From: Rossi, Steph @ Sydney <Steph.Rossi@cbre.com>
Sent: Thursday, 27 January 2022 10:58 AM
To: Alejandra Rojas <Alejandra.Rojas1@det.nsw.edu.au>
Cc: Spedding, Stephen @ Sydney <stephen.spedding@cbre.com.au>; Carmody, Greg @ Sydney <Greg.Carmody@cbre.com>; Jack Bruderlin (Jack Bruderlin) <Jack.Bruderlin@det.nsw.edu.au>; Lawler, Nicholas @ Sydney <Nicholas.Lawler@cbre.com>; Chris McGillick <CMcGillick@ethosurban.com>; Ella Coleman <EColeman@ethosurban.com>
Subject: RE: RFI - DPIE further comments

1. *The Department previously requested details of internal layout of Childcare Centre and internal play spaces. This information has not been provided. Please submit amended plans with the internal layout with test fit concept plan to demonstrate compliance with the required play area for 40 preschool children.*

DRAWING NO. N174701-10-01 SHEET 01 OF 01 ISSUE P3

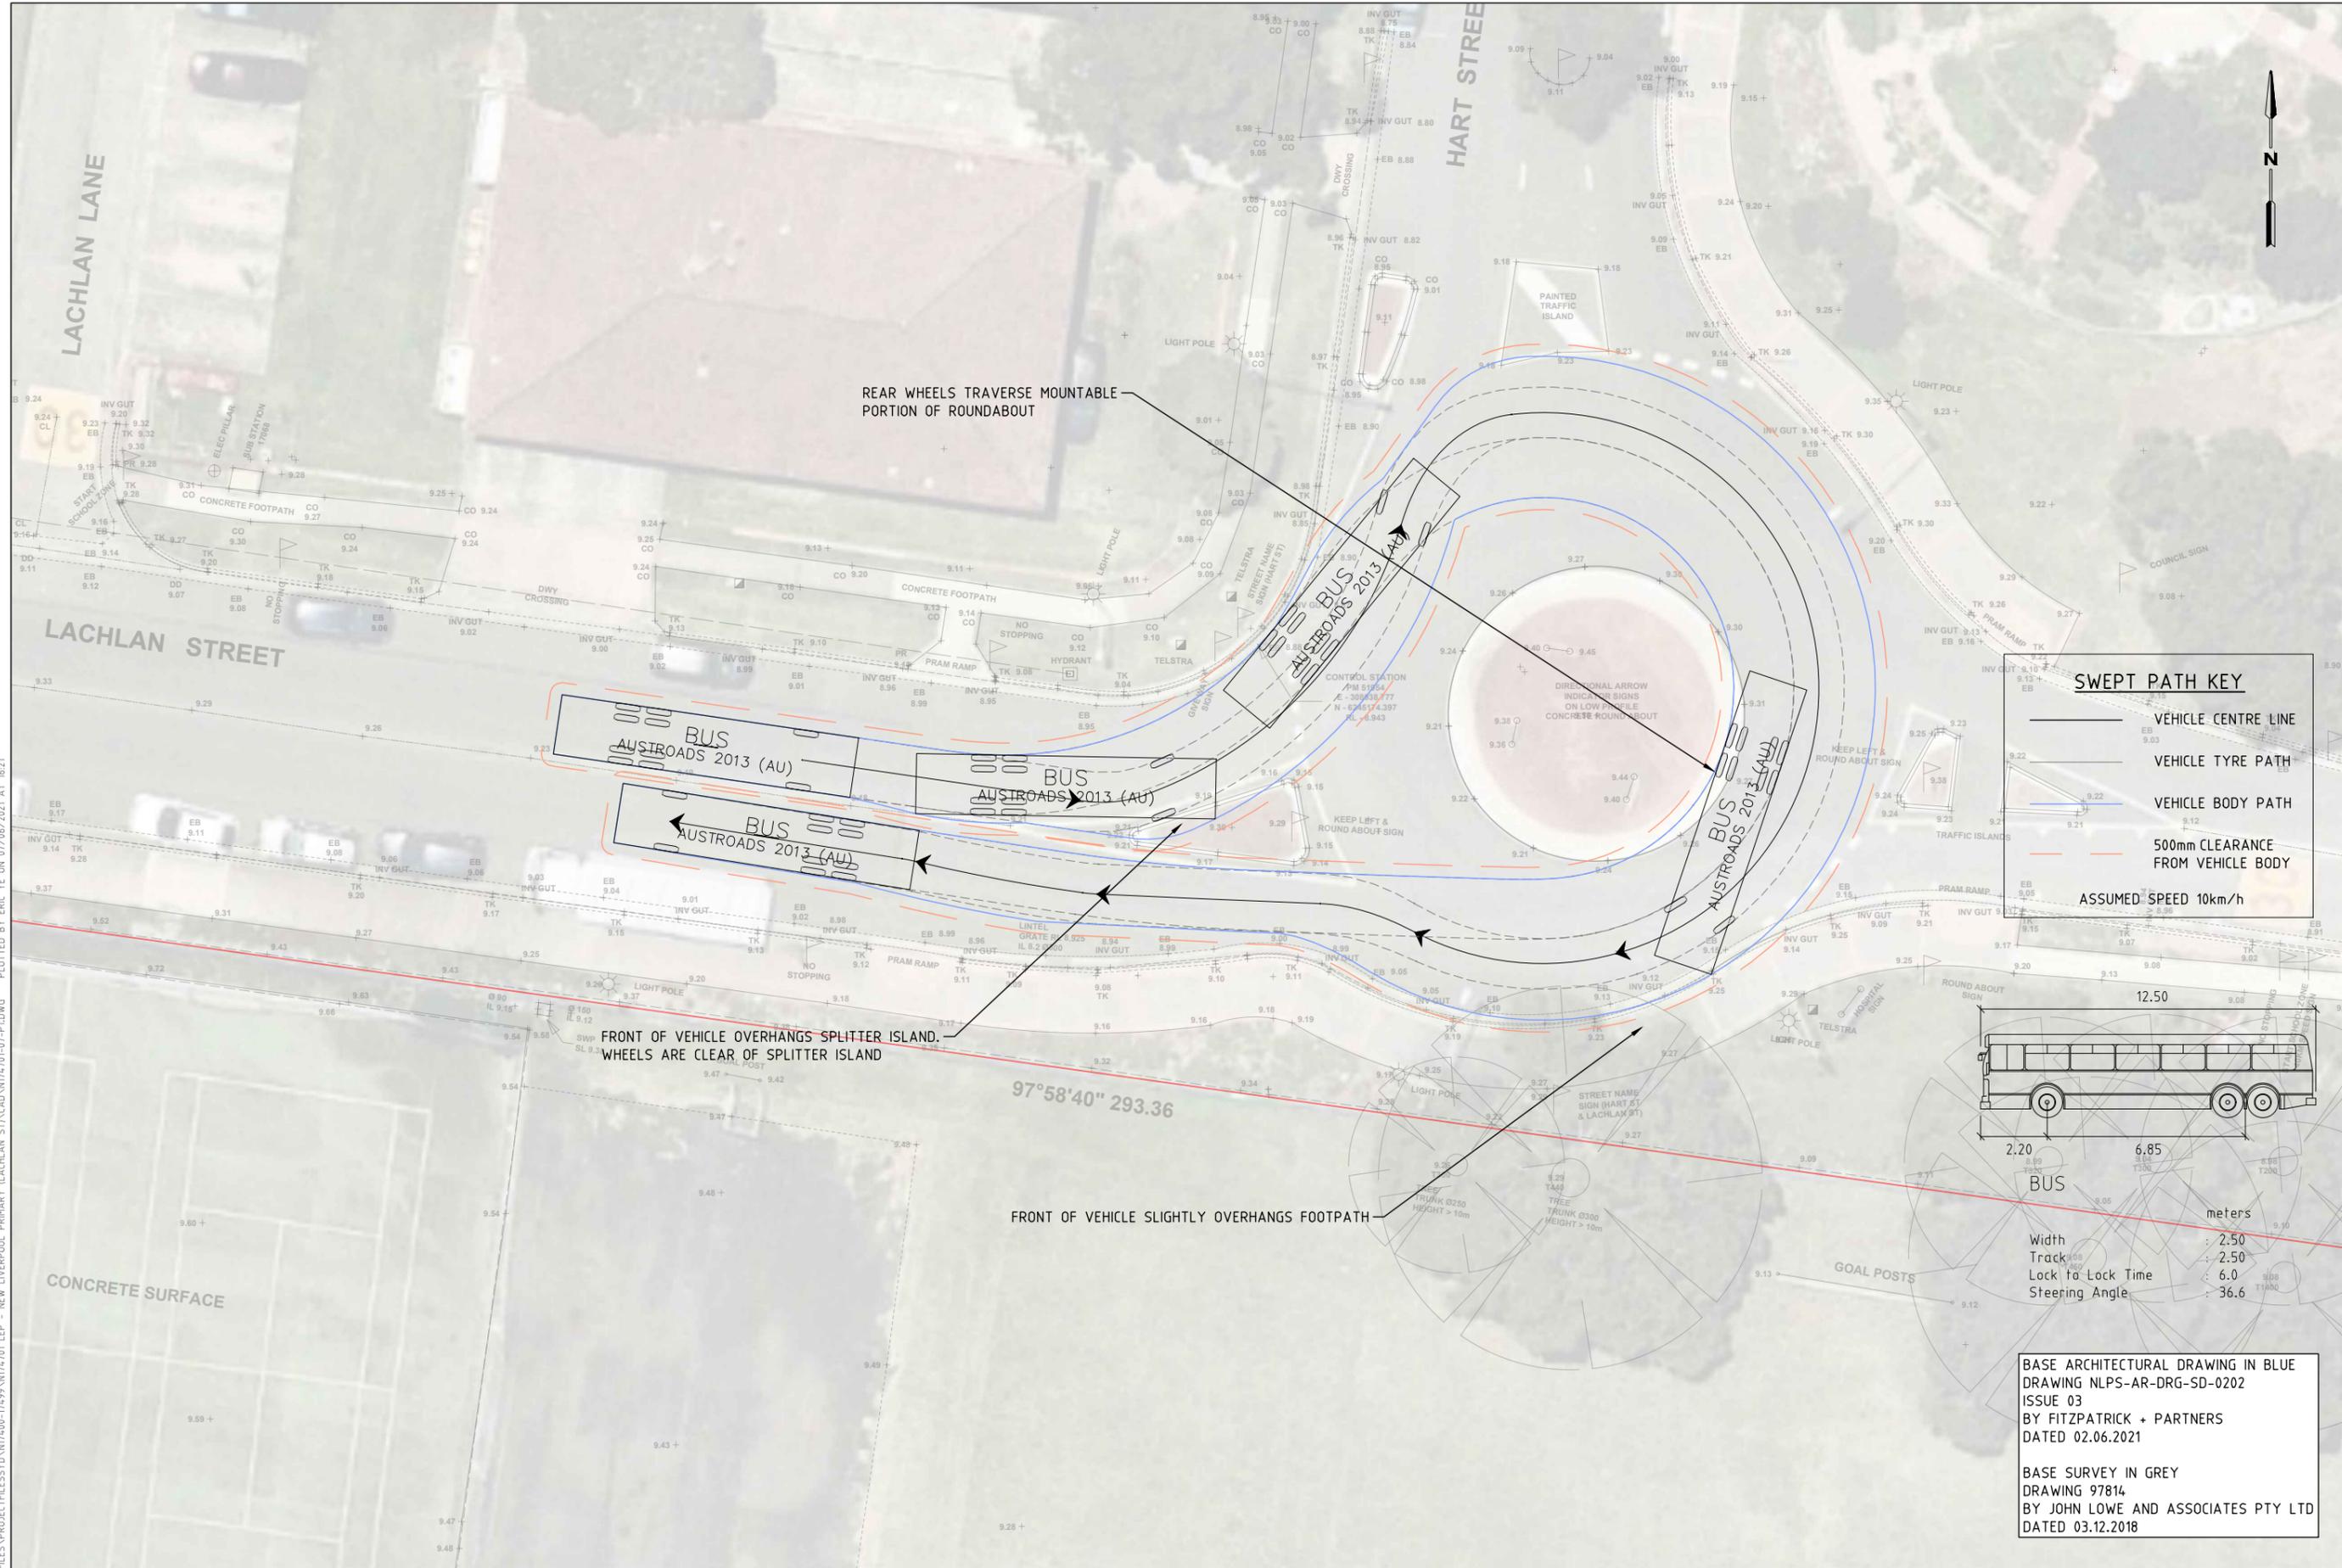
3. *The submitted drawing no NLPS-AR-DRG-0203 shows the manoeuvring of MRV vehicle's turning path. The Department notes that the allocated hardstand space is not sufficient for MRV manoeuvring and that the MRV would encroach into the waste area. Please address this issue and relocate/resize the hardstand area or relocate the vehicle turning circle area to allow for adequate manoeuvring of MRV within the site.*

Refer to **ATTACHMENT C**. The bin storage area and surroundings have been reconfigured to show the bins to the south of the hardstand and therefore provide increased manoeuvrability for a medium rigid vehicle. The bins and bin wash area have been shown on the plan in accordance with the requirements of the Waste Management Plan.

Figure 2 Pedestrian travel path between the preschool and the proposed 15-minute on-street parking spaces on Lachlan Street

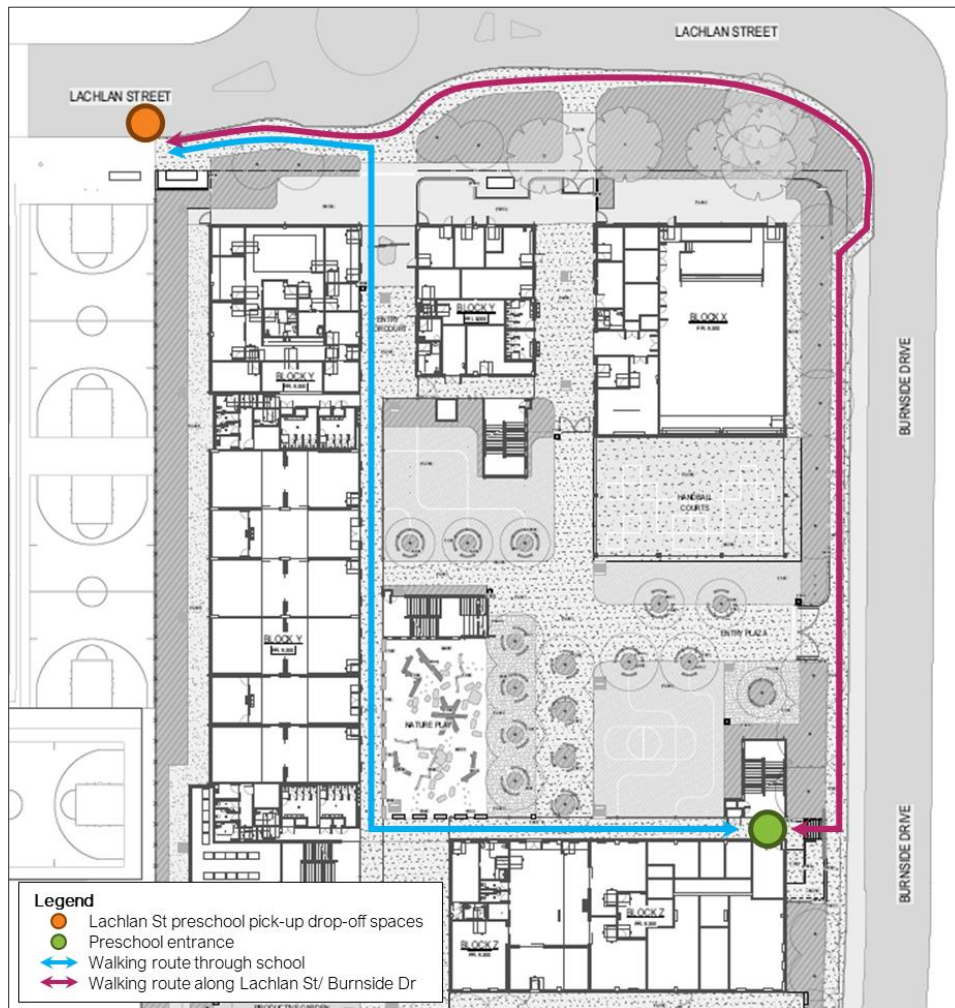
5. *The Department requested additional information regarding parking facility for the preschool users or else an alternate area is to be identified where parents can park during arrival / departure (when coinciding with the school drop-off/pick-up times). Please address this issue. The response to RFI letter says designated preschool parking spaces of 15mins length of stay will be provided between the hours of 7am to 8:15am and 4pm to 6pm adjacent to the school on Burnside Drive. A detailed study is required for capacity of parking on burnside drive between this time.*

In addition to respond to DPIE's request during school drop off and pick up hours, 3 designated 15 minute preschool on-street parking spaces are proposed on Lachlan Street between the times of 8am- 9:30am and 2:30pm to 4pm to accommodate preschool drop off and pick up should it be required to coincide with the school drop off and pick up. Noting that Preschool pick up and drop off will be discouraged during this time to assist in reducing traffic congestion around the school at these key busy periods.
